Recommendation Report for Planning Permission for Works or Extension to a Dwelling

REF NO: BR/39/25/HH

LOCATION: 34 Crescenta Walk
Bognor Regis
PO21 2XS

PROPOSAL: Demolition of detached single garage. Rear and side single storey extension.

PROPOSED ELEVATIONS

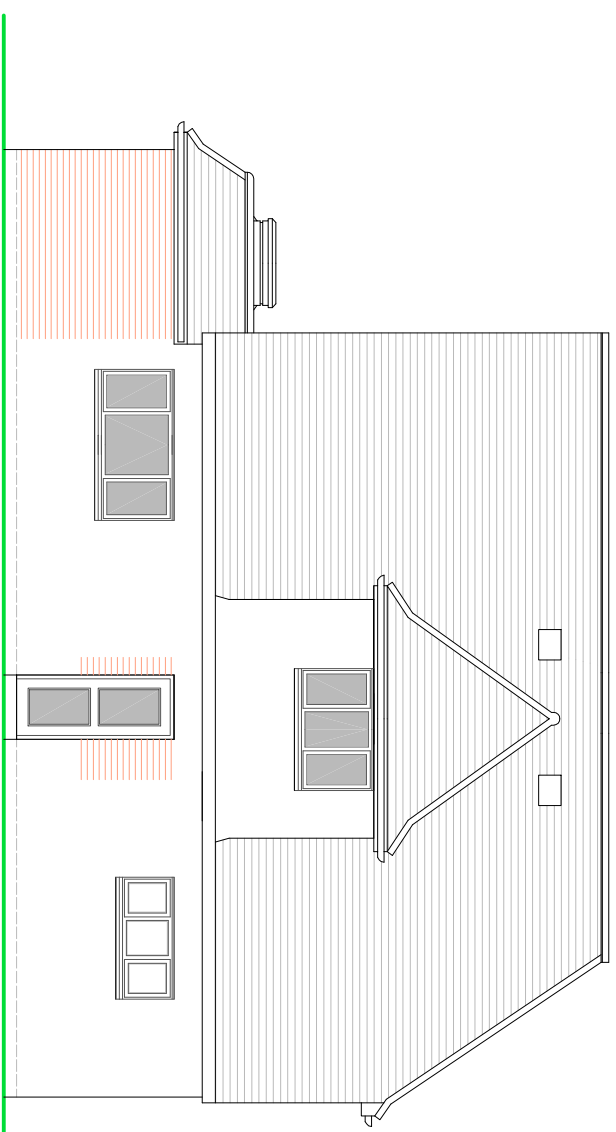
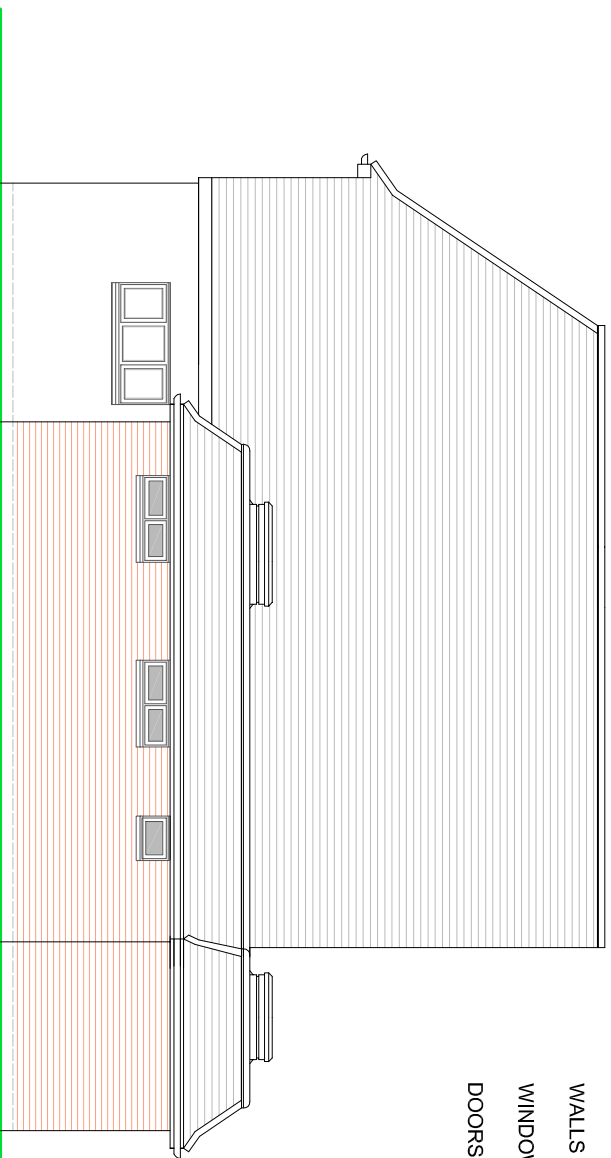
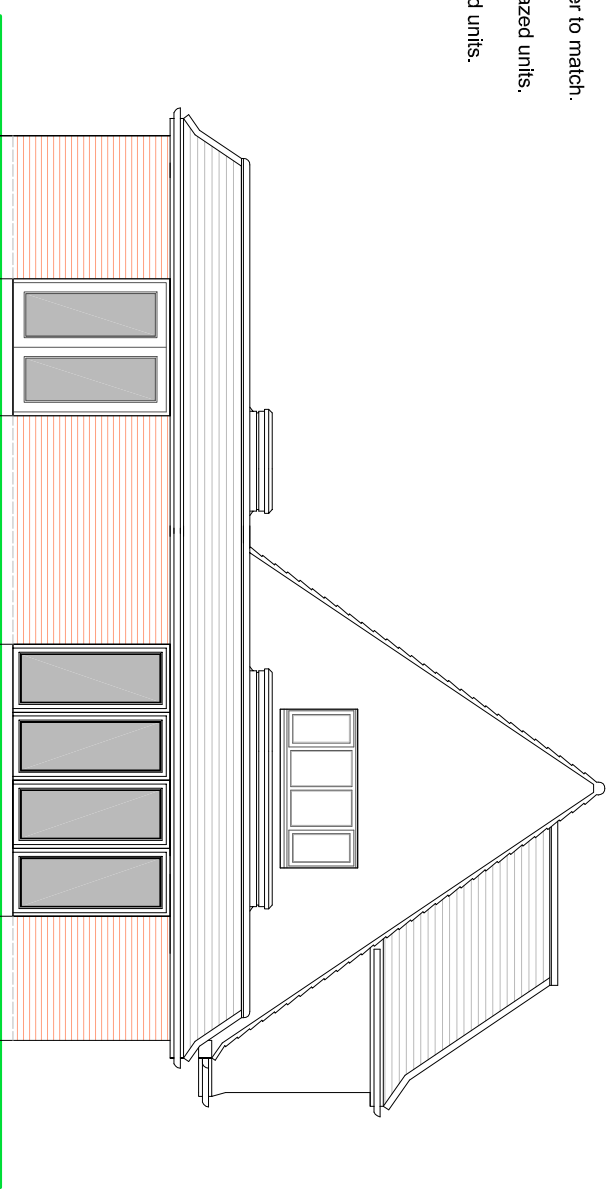
The site is a two storey detached dwelling. This application proposes a side and rear wraparound extension. The side extension element would have a splayed north eastern flank elevation, with a width of 3m to the front, widening to 5.3m at the rear. The extension would project 2.5m beyond the existing rear elevation of the property with a crown roof. The addition would obscure the elevations of the original dwelling on two sides, however, it would be a single storey addition and it would remain visually subservient to the host dwelling when viewed from the front, in accordance with policy D DM4 of the Arun Local Plan. An additional door is to be inserted into the existing south west elevation. This is acceptable in accordance with policy D DM1 of the Arun Local Plan.

The proposed materials are face brick and painted render to match the existing. The pitch sections of the roof would be artificial slate, which is not currently present on the dwelling. However, there are examples of this material elsewhere on the street and its inclusion would not be unduly harmful.

The extension would feature high level windows to the front and side elevations and two sets of patio doors to the rear. The windows would be sited at ground floor level and would not result in any overlooking to neighbouring properties.

**PROPOSED GROUND FLOOR PLAN**

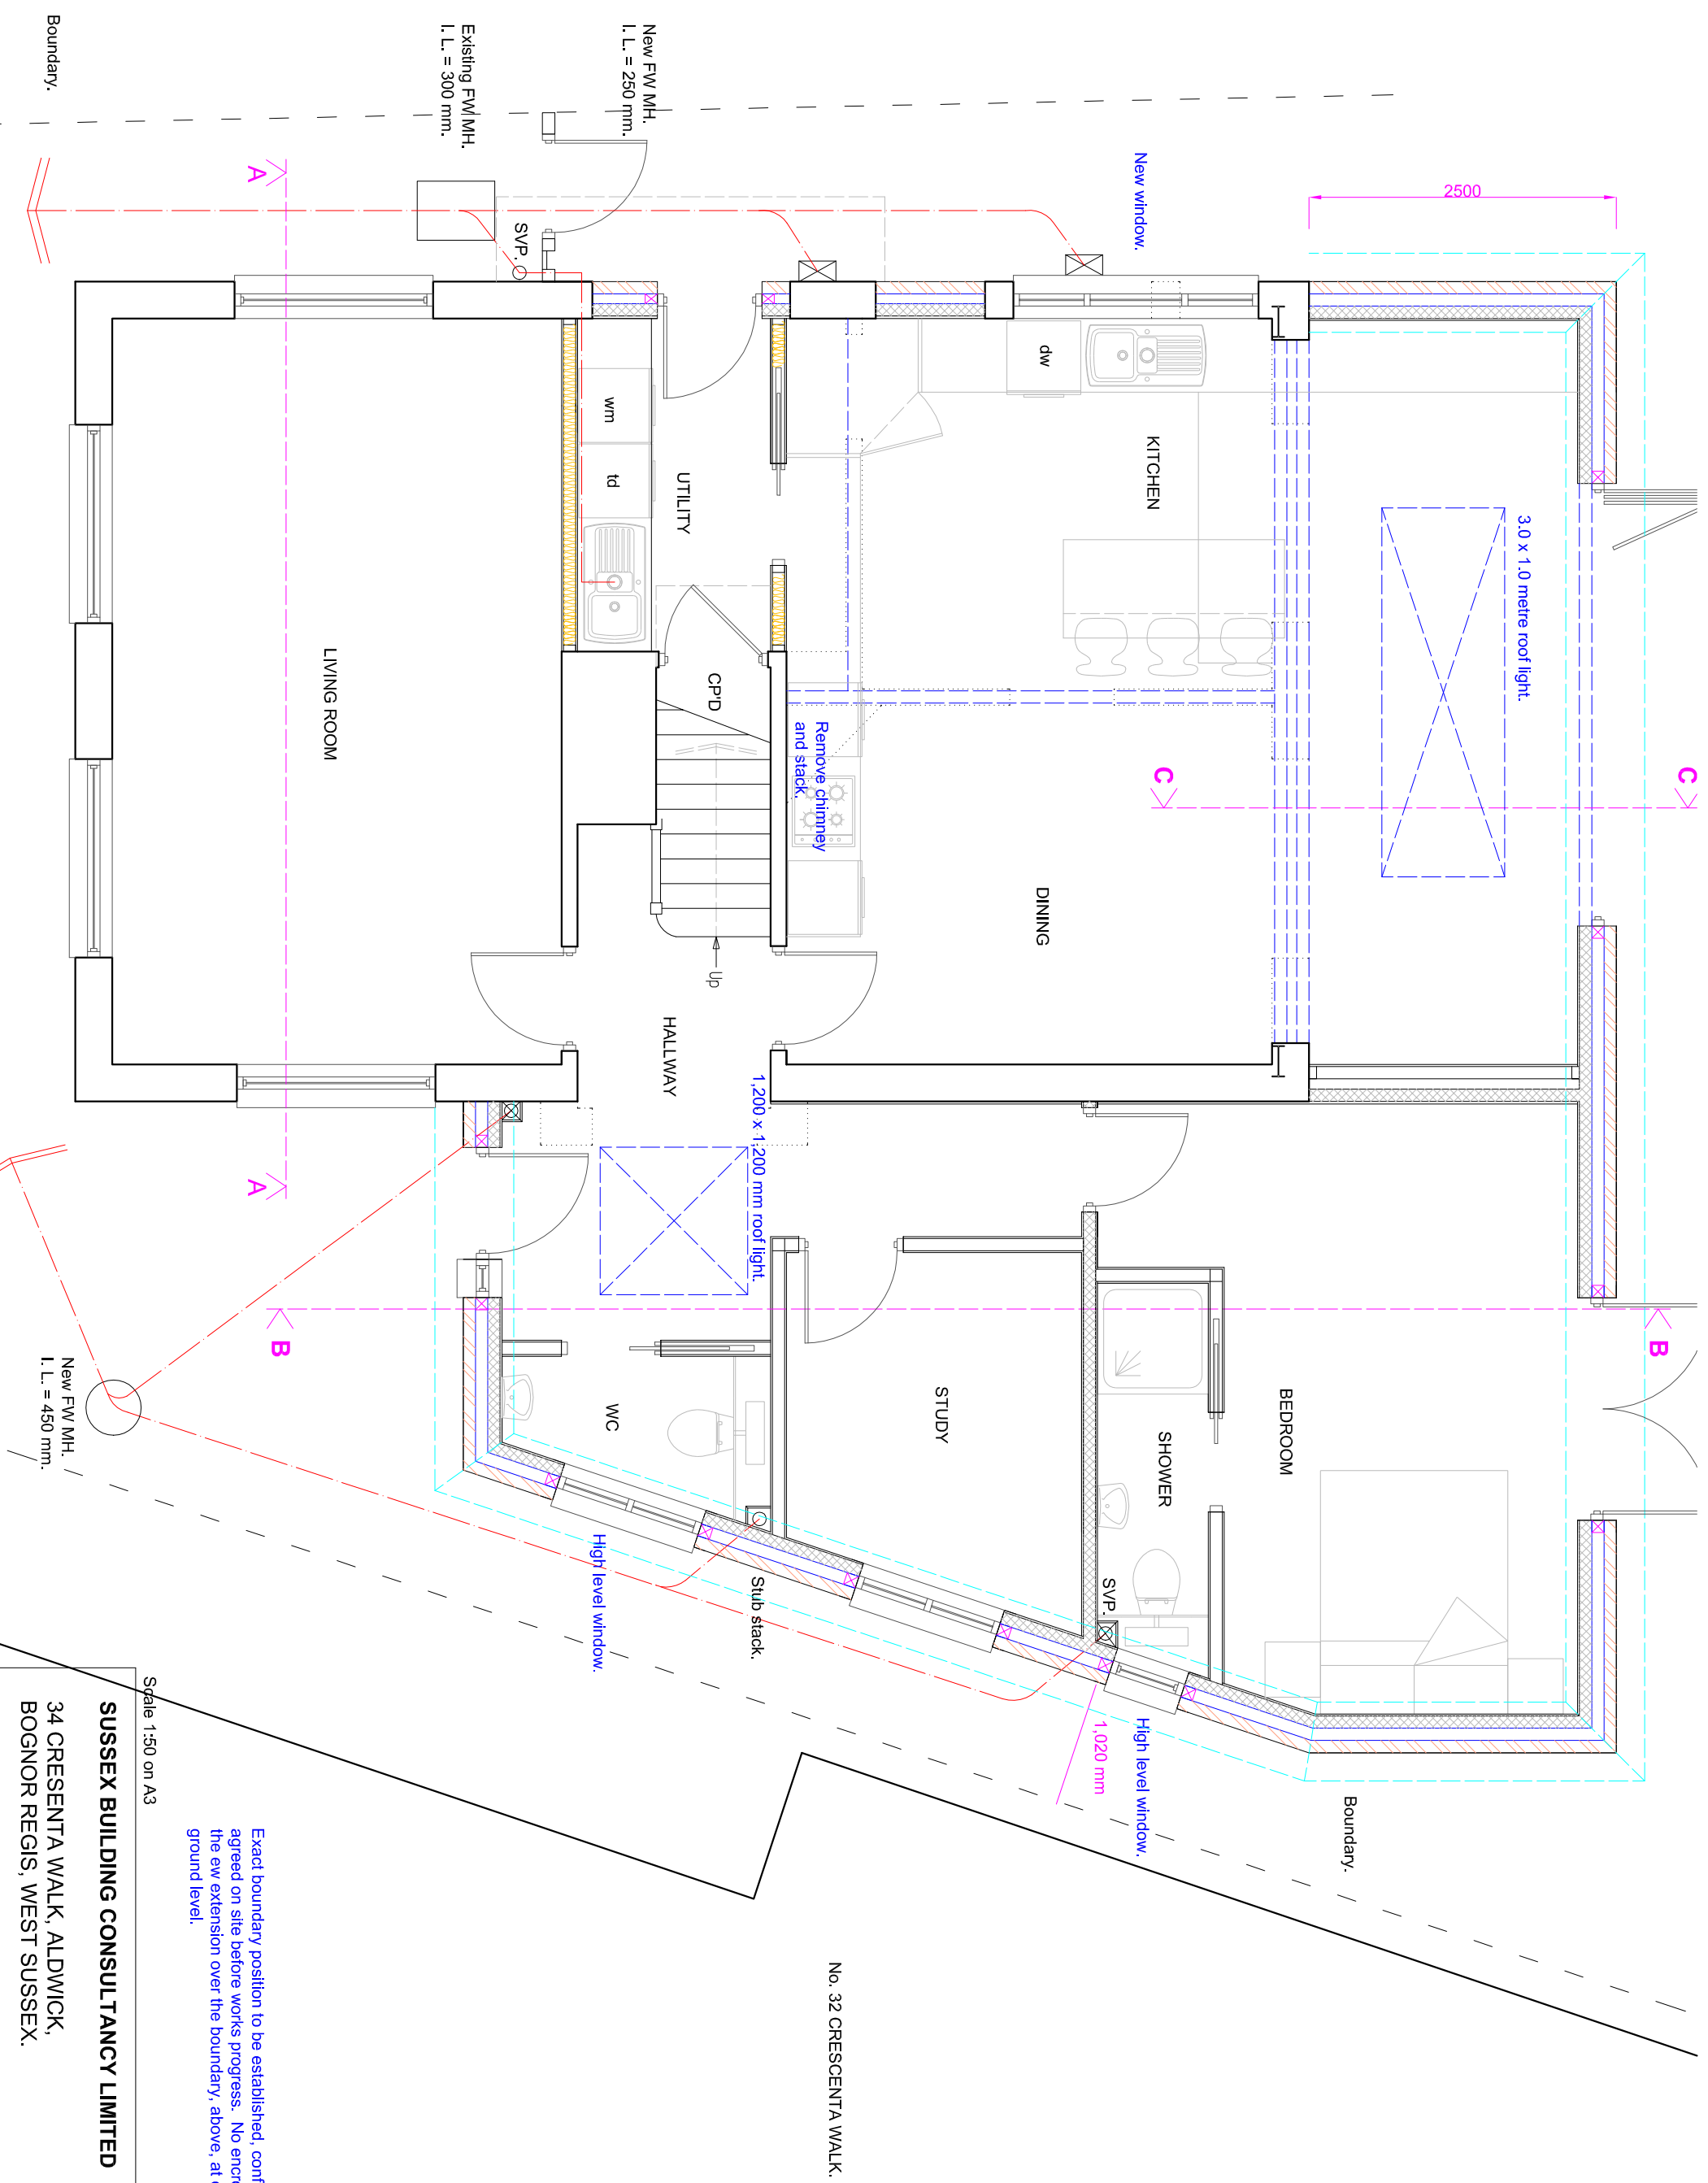
The property has neighbours on either side and to the rear. The proposed extension would be single storey and the host dwelling would retain a rear garden depth of 8.9m. The extension would not adversely impact the neighbour to the rear. The side extension element would extend out to the north east and would leave a separation distance of 1m to the boundary. The maximum height of the extension would measure 3.3m, and this would not result in overbearing or overshadowing effects to the neighbour to the north east. The rear extension element does not extend beyond the rear elevation of either neighbour at the rear and therefore, this element would not result in overbearing or overshadowing effects to neighbouring properties.
